e. Detention/Water Quality Criteria

IV. Drainage Facility

b. Water Quality & Detention

### DRAINAGE A-2 STA 22+00.00 TO 26+91.51

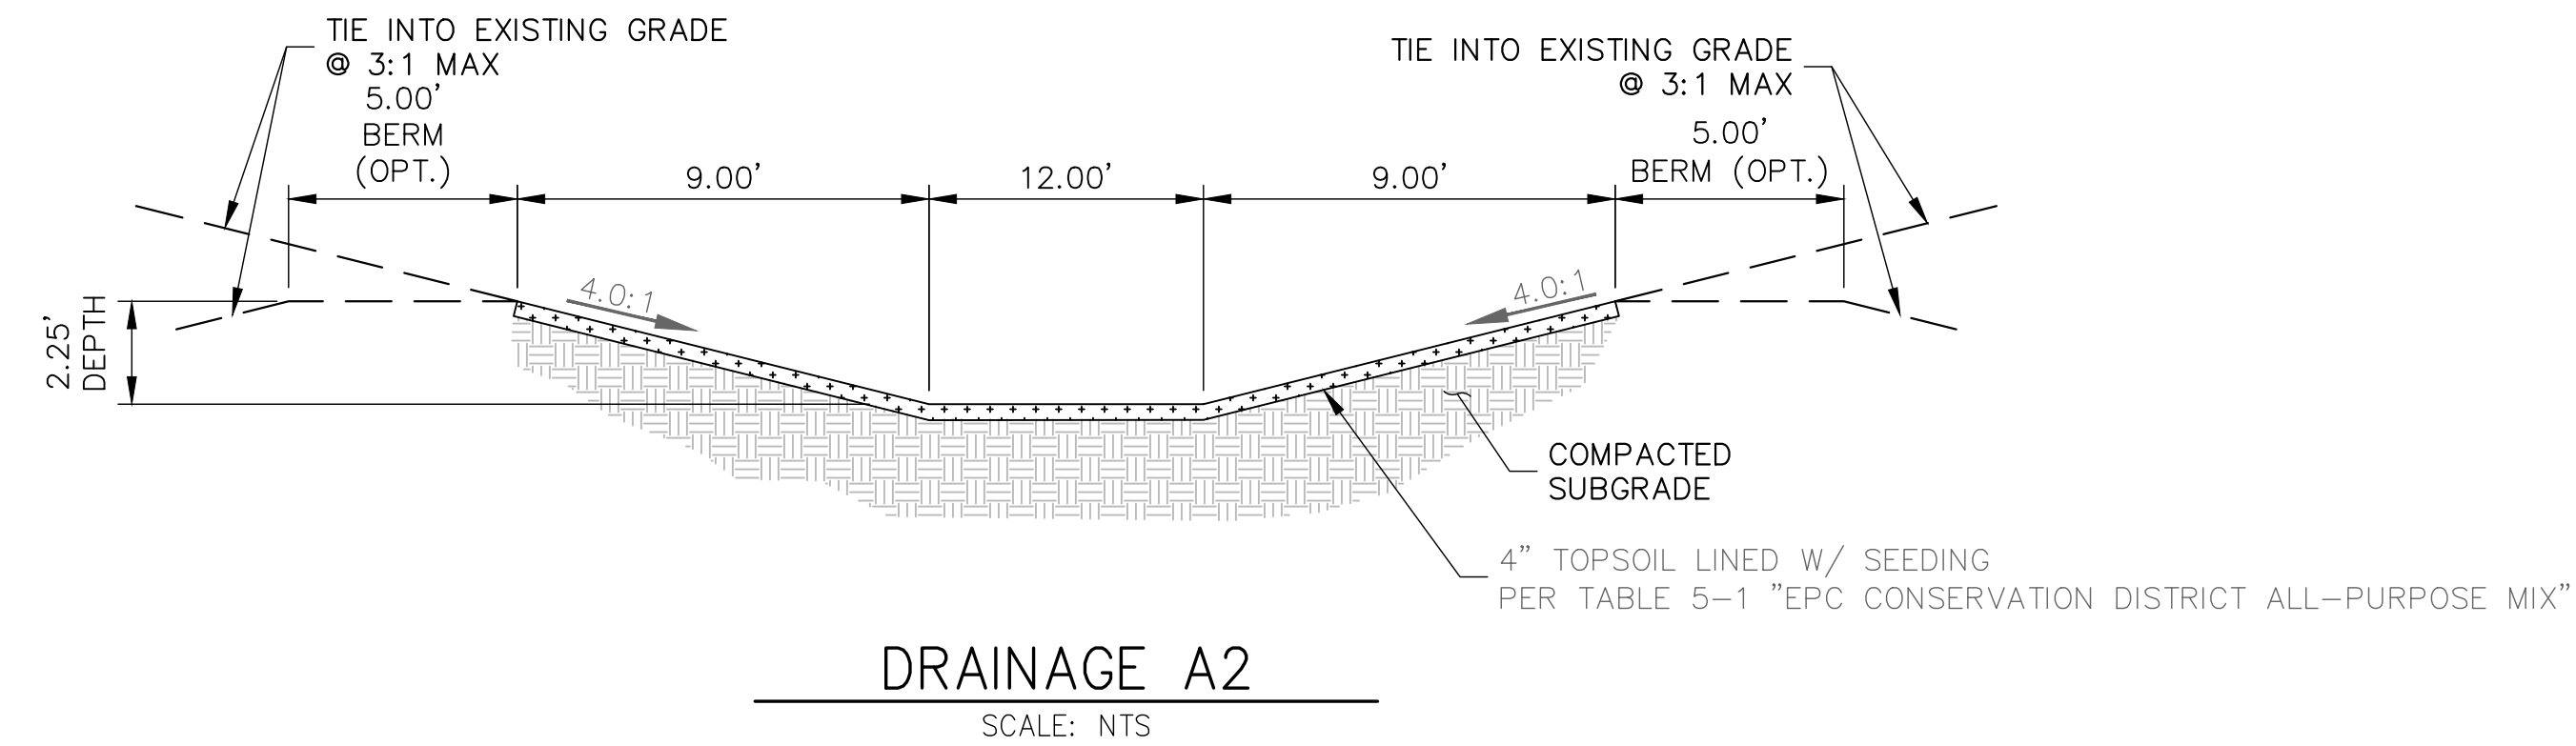
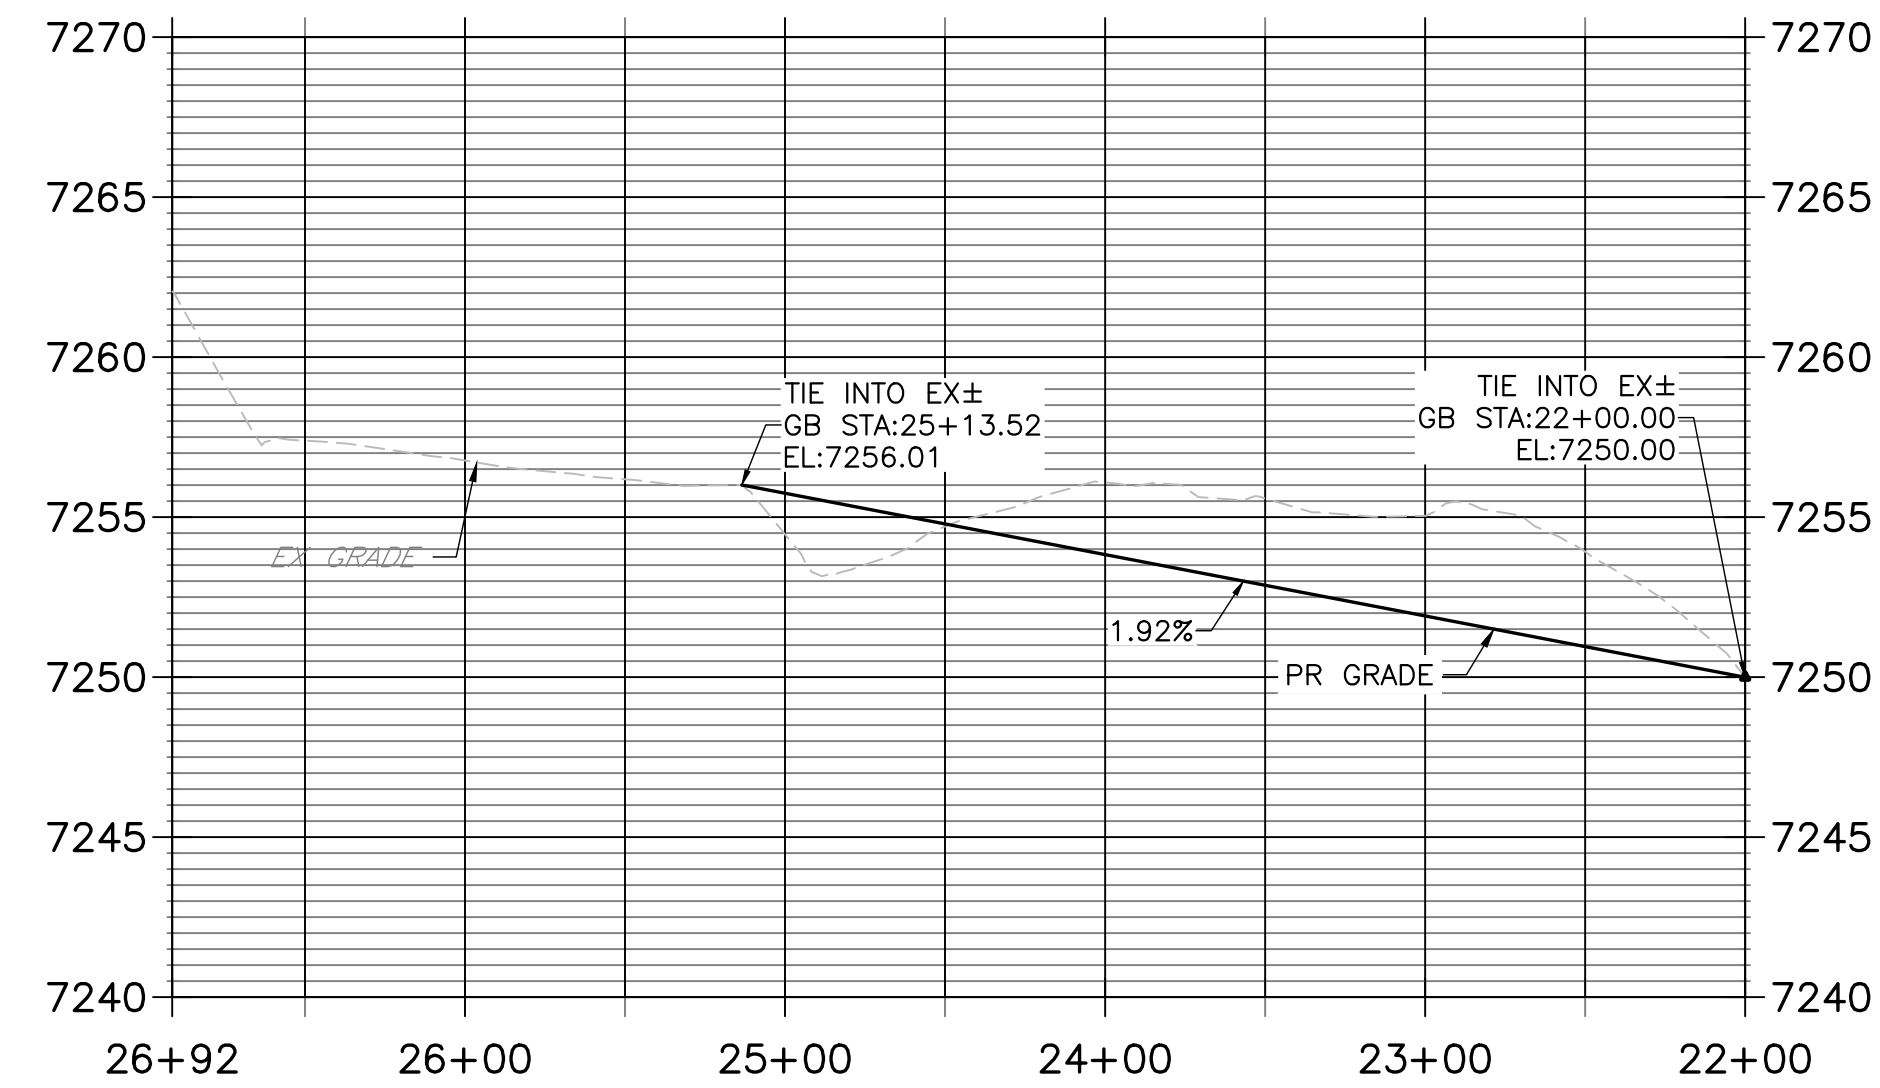
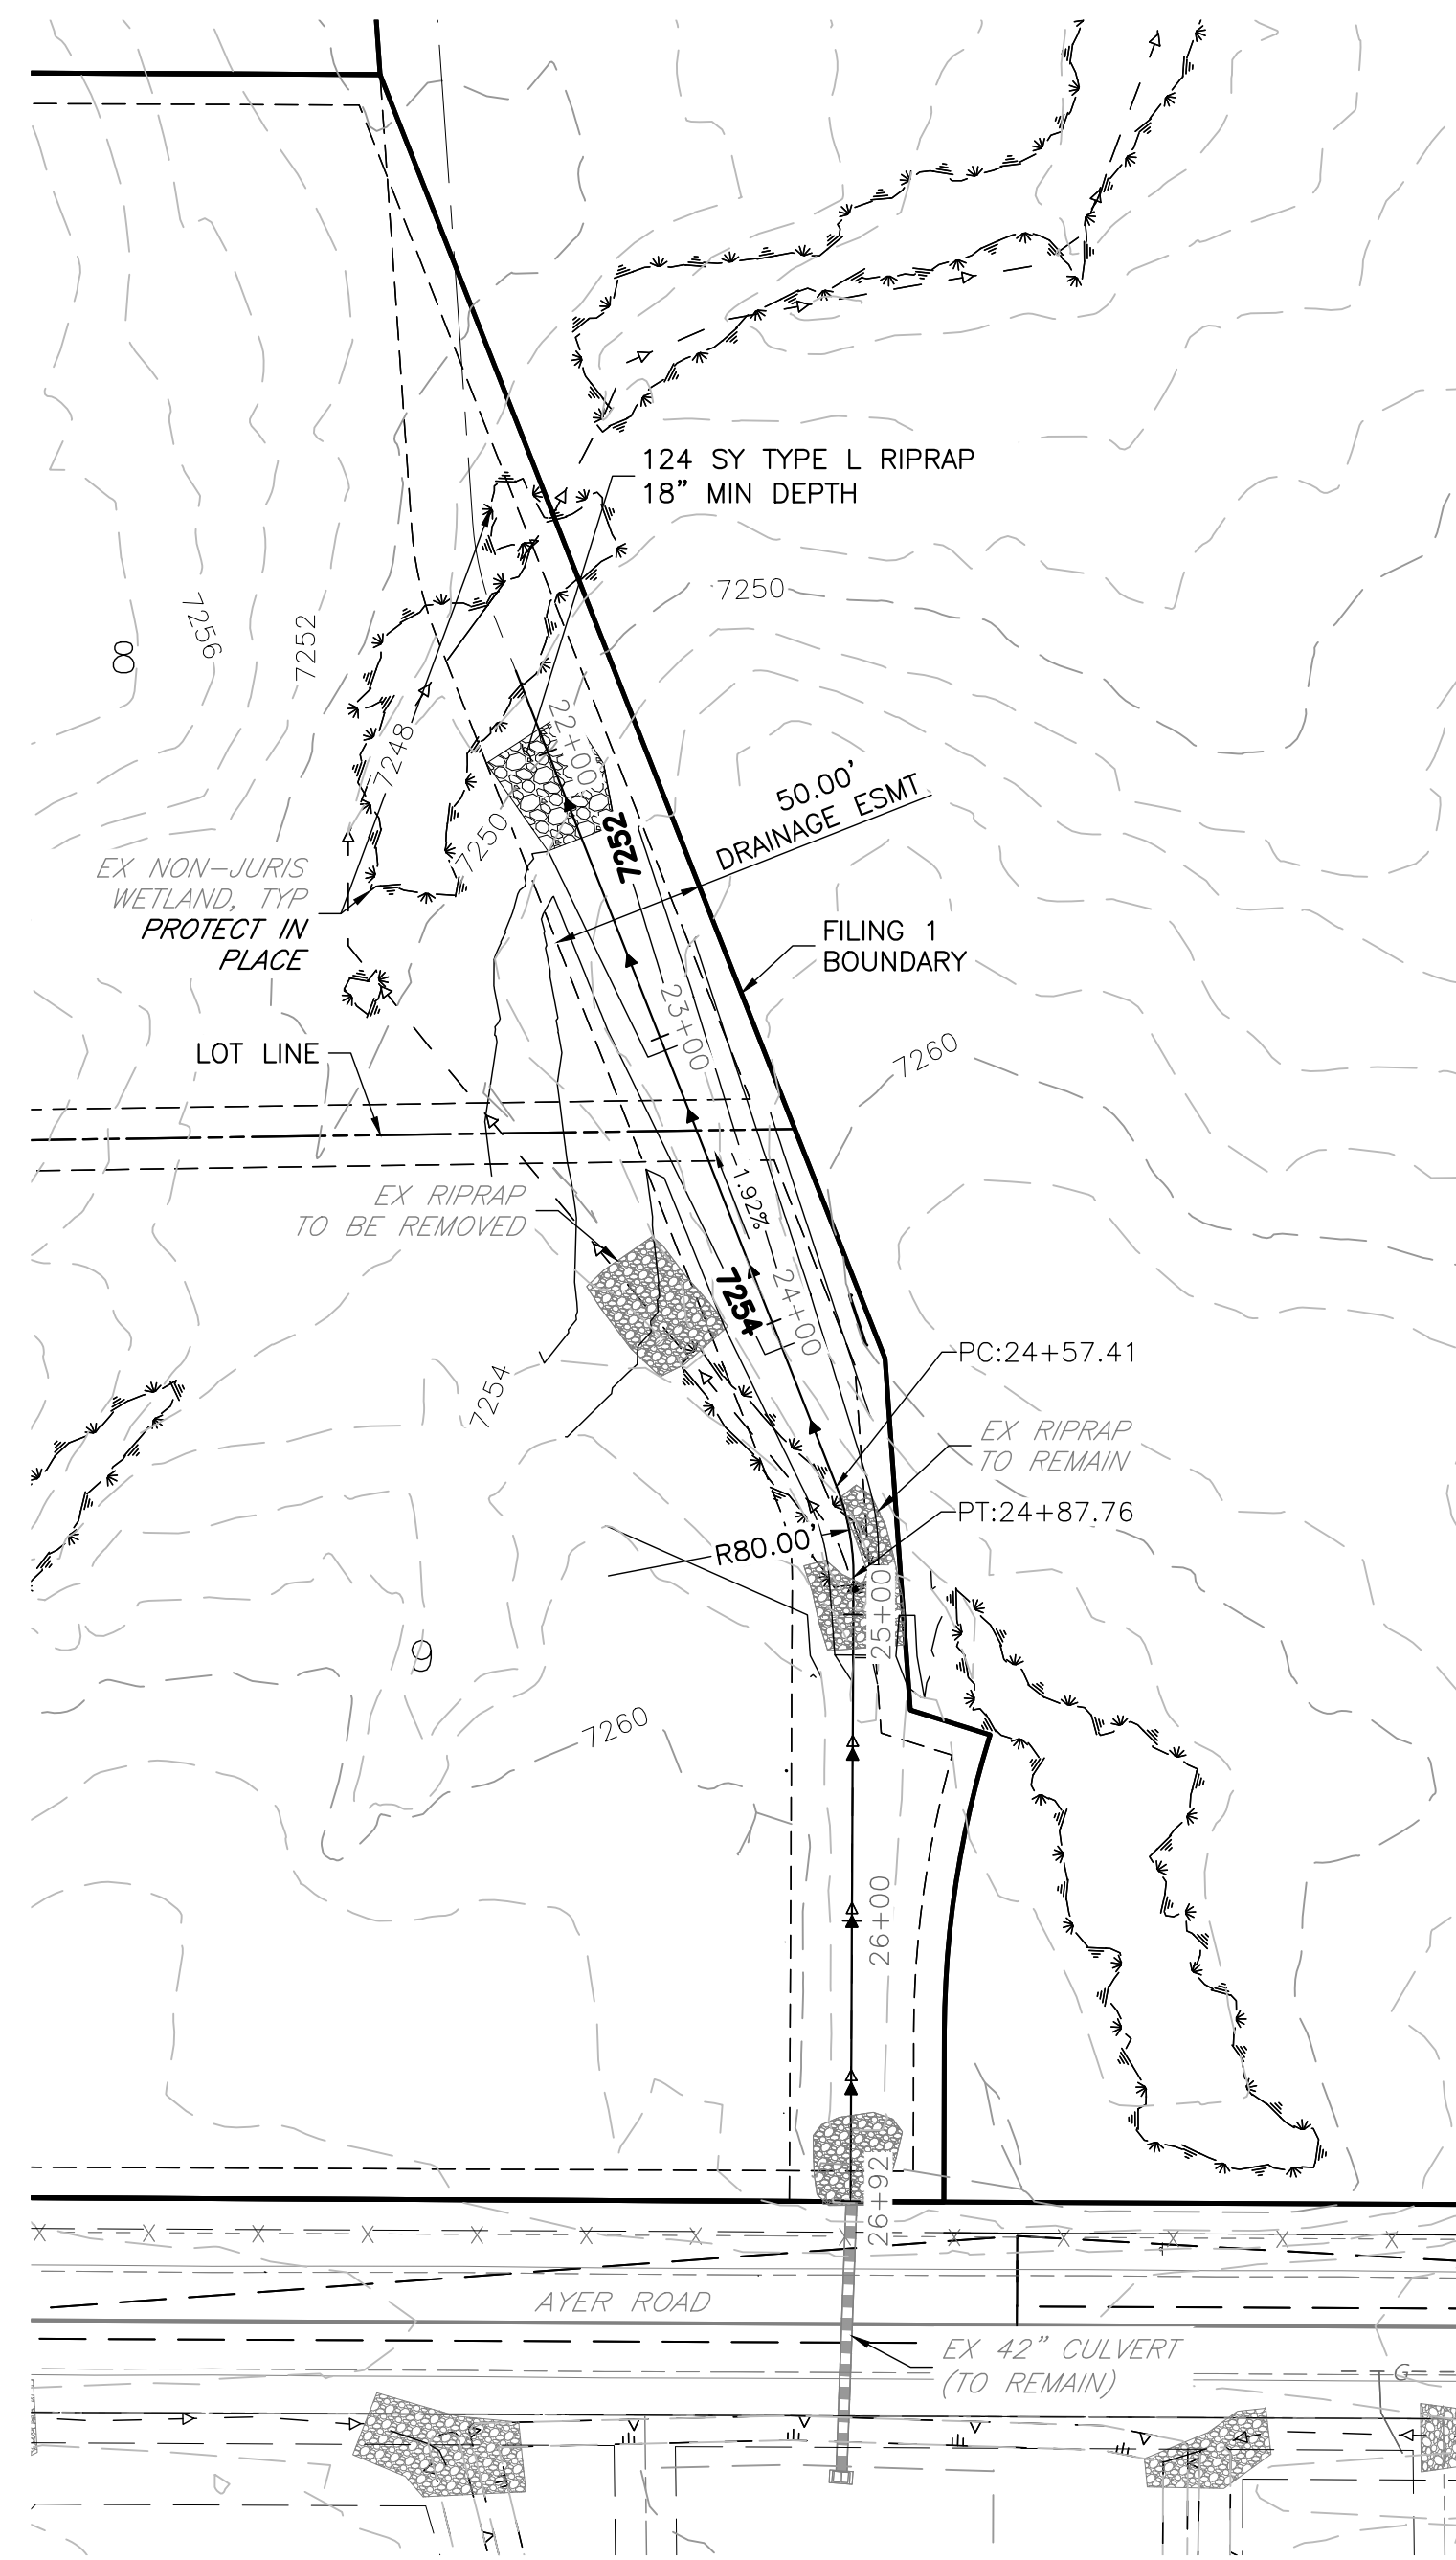
please include velocities of the swale
